From: Michael Eastham <Michael.Eastham@arun.gov.uk>
Sent: 23 April 2020 21:13
To: Planning.Responses <Planning.Responses@arun.gov.uk>
Subject: FW: BN/37/20/DOC - Land Rear of Lillies, Yapton Road, Barnham

I am currently looking at this DOC application for a cycle path in relation to a condition which was set by the inspector at appeal.

SCALE	1:500 @ A2	DATE	FEB 2020
DRAWN	CLS	CHK	JGF
DRAWING NO.	17748-BARN-5-512	REV	B
TITLE	YAPTON ROAD BARNHAM		
DETAILS	Footpath Link & Typical Footway Constructon Detail

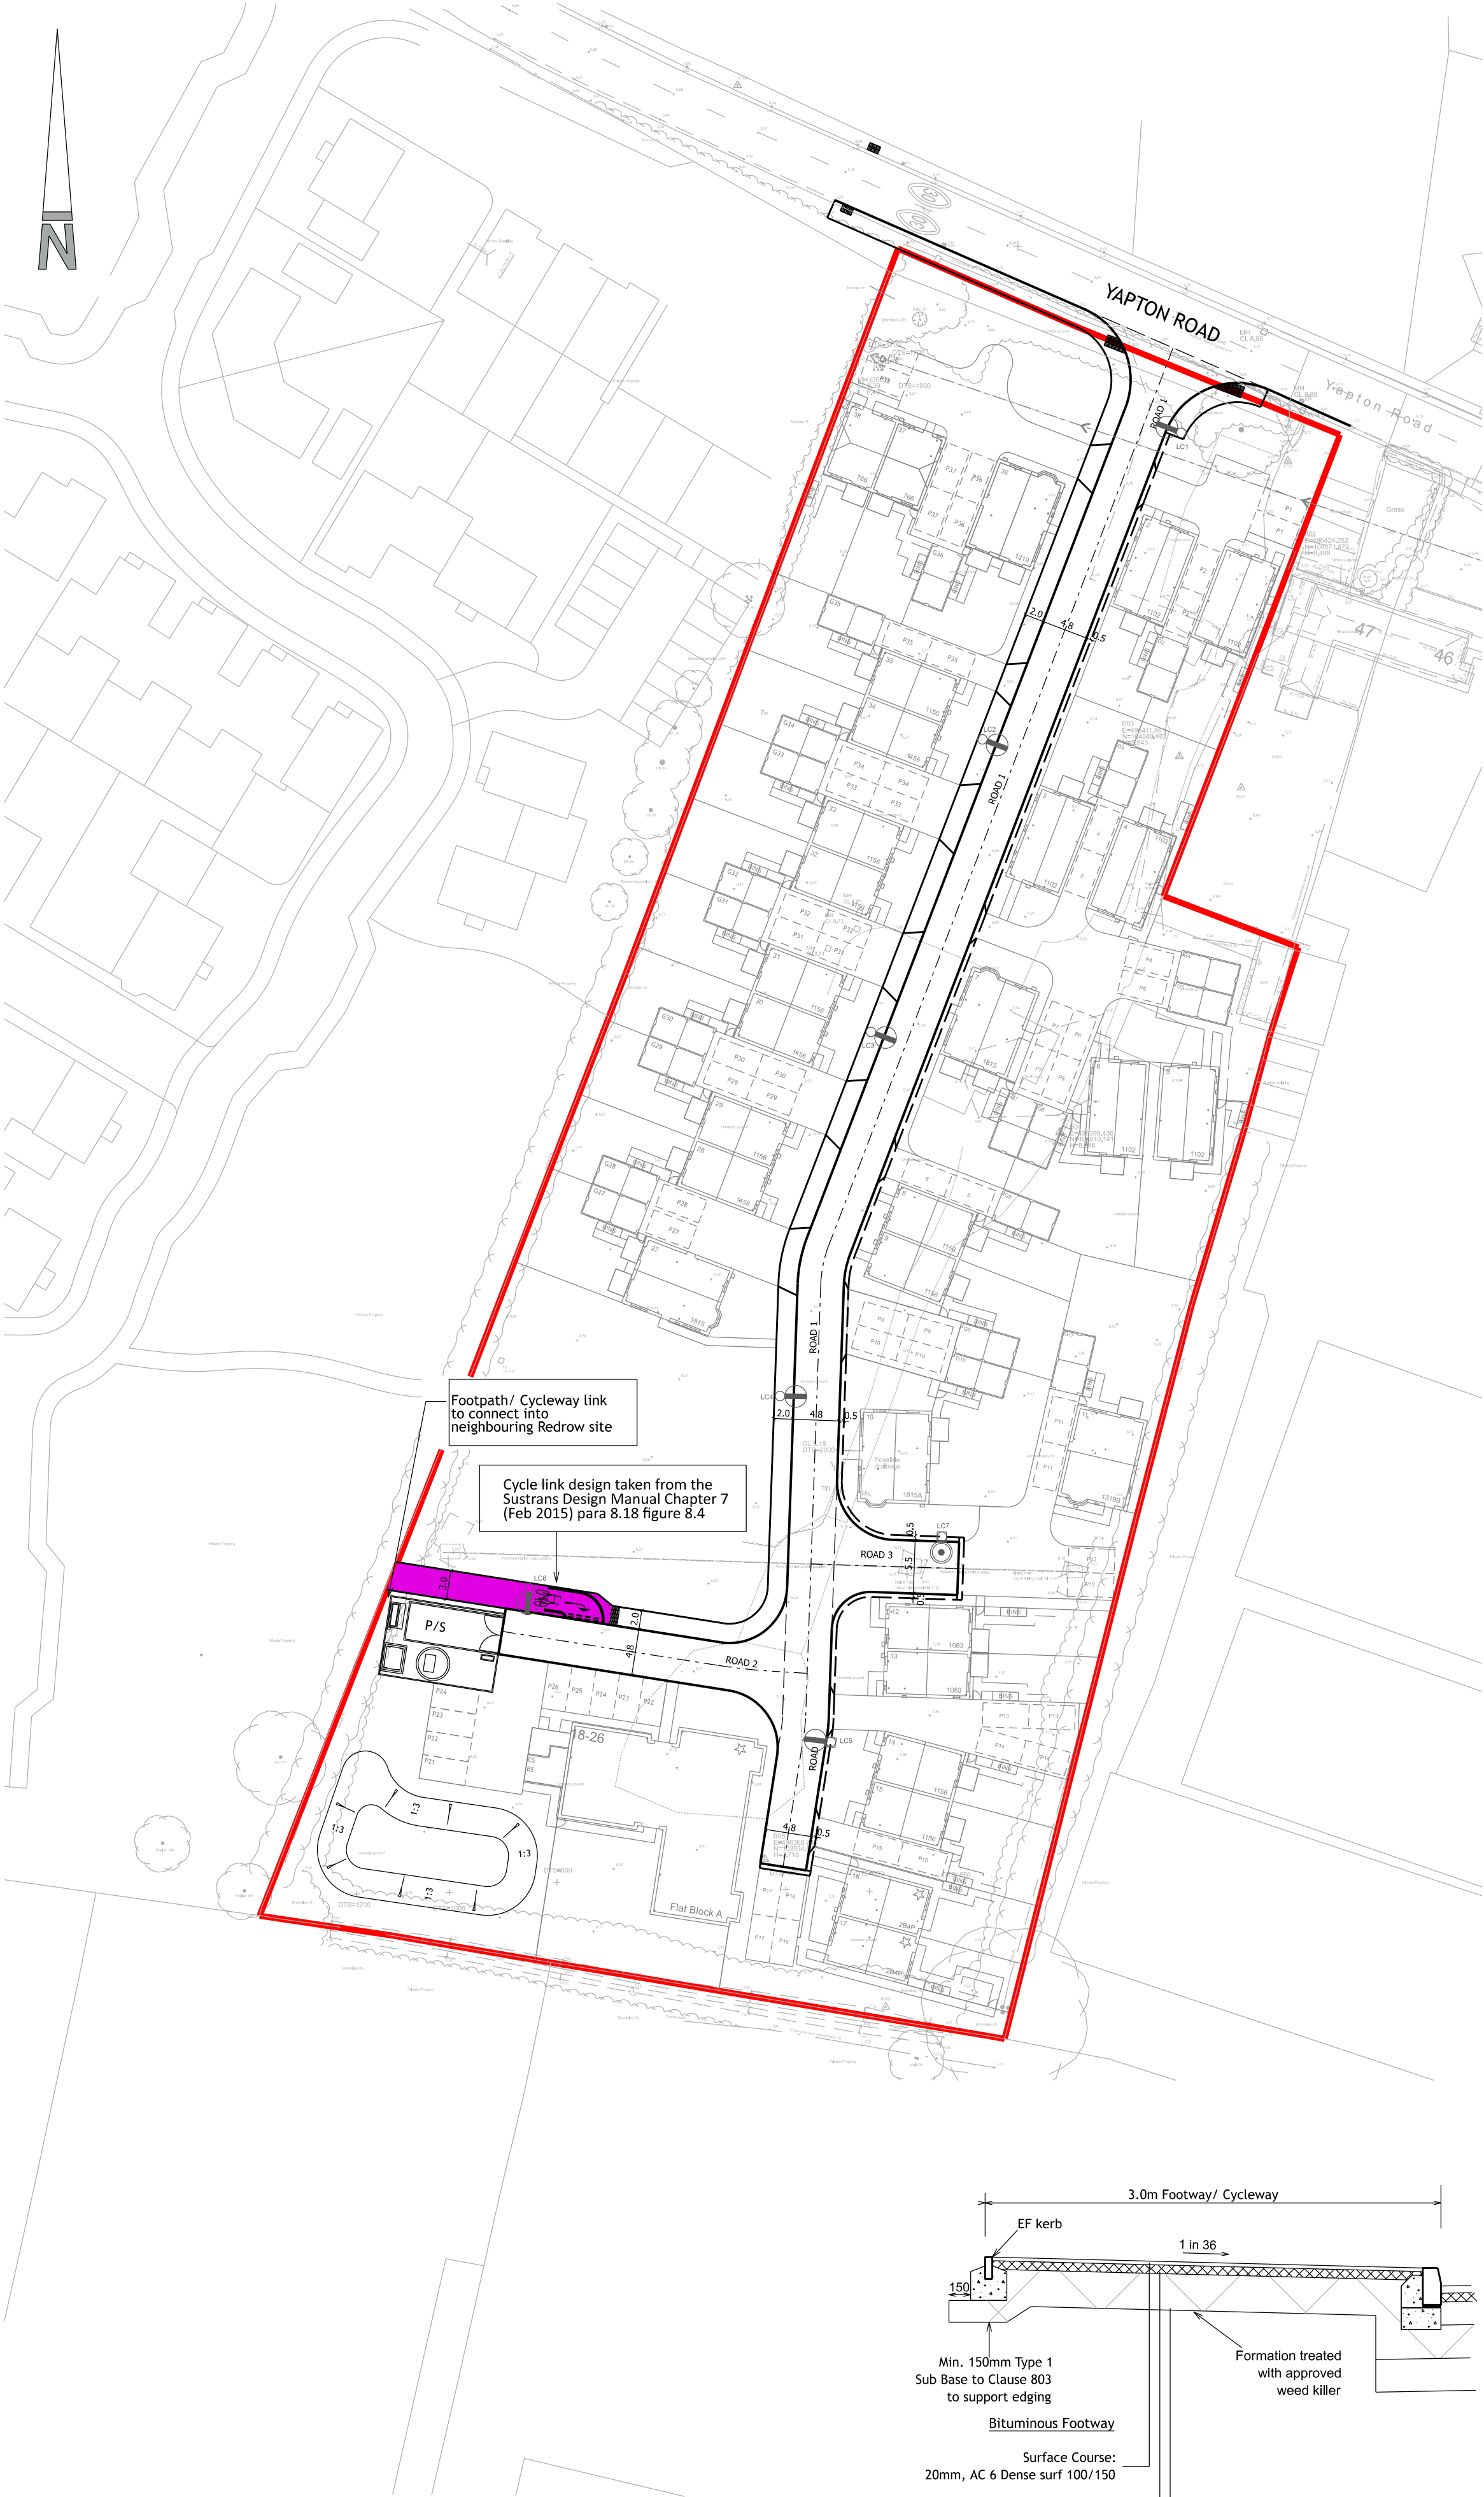
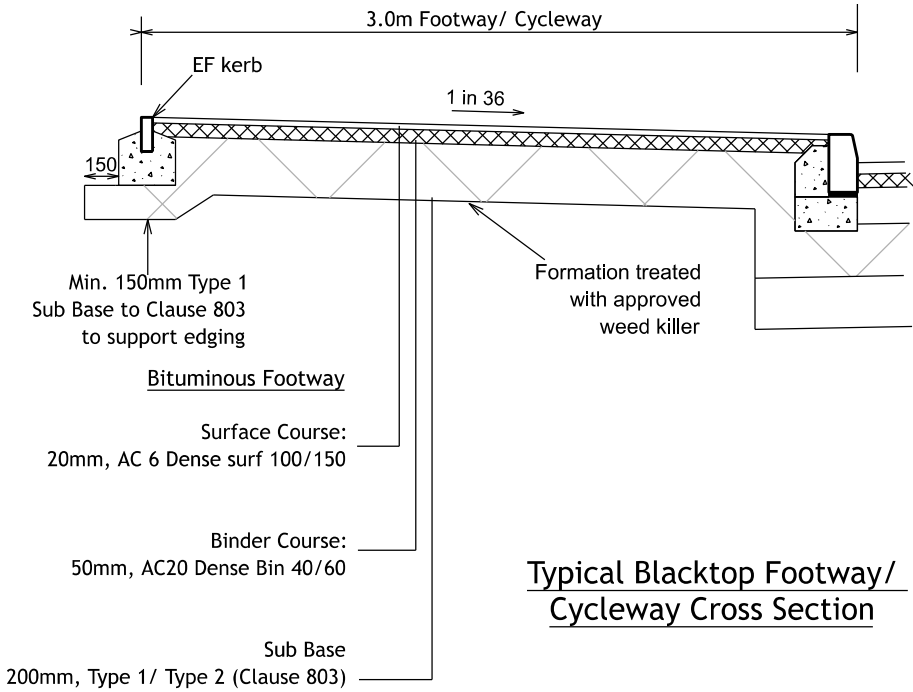
Please can you ask the applicant to confirm if they will be widening the footway on yapton road to meet the existing 3m footway, already in situ as part of the (redrow) angel nursery development. This only needs to be 3m wide on Yapton Road, the internal road can stay at 2m, and the proposed cycle path connecting the two sites can stay as per the plan.

We would prefer this is road safety audited, a 1 and 2 audit will be required, before the S278, please can this be arranged.

Many thanks for getting back to me so promptly. I have spoken with our implementation team who has been in contact with the local member for the area. Apparently this is something which is supported locally however; the need for a 3m path would only be required on Yapton Road, the internal access could still remain at 2m.

Unfortunately it seems no RSA process was raised at any of the previous applications, so as it stands the proposal to continue the 3m footway along the Yapton Road only would be achievable at this stage without any other changes being required. This would benefit the whole community, have amenity benefits, and also provide consistency with the adjacent development. Please can you ask the applicant to re-consider?

Whilst plans submitted show a cycle path linking the internal site roads of the adjacent housing development (known as angel nursery site) it has been brought to my attention that there should also be a cycle path (3m wide) on the left hand side of the access, linking into the development.

From a planning perspective we would not wish to see an opportunity for encouragement of sustainable travel like this to be missed. Also it is not logical for the path to change from a 3m wide shared use cycle/footpath to a footpath on such a short section of footway. Hopefully you will see the logic, and as such would appreciate it, if you can ask the applicants to revise the drawing to include the extension of a 3m path along yapton road, from the angel nursery side, into the proposed access.

I have also noticed this will need road safety auditing, and will require both a stage 1 and 2 audit, which can be undertaken together to ensure all highway safety issues have been considered.
Therefore until I receive further information I am unable to discharge the condition.

In principle, to maintain continuity we have no objection to a 3m wide footpath on Yapton Road. However, I don't think the existing footpath is 3m wide and nor has the neighbouring site started their S.278 works yet.

I cannot agree this until our engineers have assessed the implications on our S.278 works. Would you be able to arrange for us to have the approved S.278 design for the neighbouring site, preferably in dwg format?

Assuming we can accept the implication of continuing a 3m footpath, I still don't agree to putting the planning condition on hold till Stages 1 and 2 of the RSA are completed as this is part of the S.278 detailed design process.

Without getting drawn into a discussion on the S.278 design, which Highways will be leading anyway, for the purpose of discharge of this planning condition, if you are in agreement of a consistent 2m wide path internal to the site, from Yapton Road to the point of connection with the adjacent site, we can get the drawing revised to reflect this as it currently shows a 3m section towards the end.

Having checked with the team, I understand the comment for a 3m wide pedestrian/cycle link has been raised for the first time and it wasn't part of the consultations at both Outline and Reserved Matters stages which showed a 2m wide path. The condition at RM notes a pedestrian / cycle link to be provided between the site and adjacent site, which a 2m wide link does.

Also, looking at the consented site layout we appear to be quite constrained along the access road, especially at the north between plots 2 and 36. Trying to accommodate a 3m link at this stage will fundamentally alter the consented site layout while making the roads the dominant feature on what is a small development. Looking at the google maps there doesn't appear to be a 3m wide footpath on the main Yapton Road itself, which has a narrow footpath on the opposite side of the road.
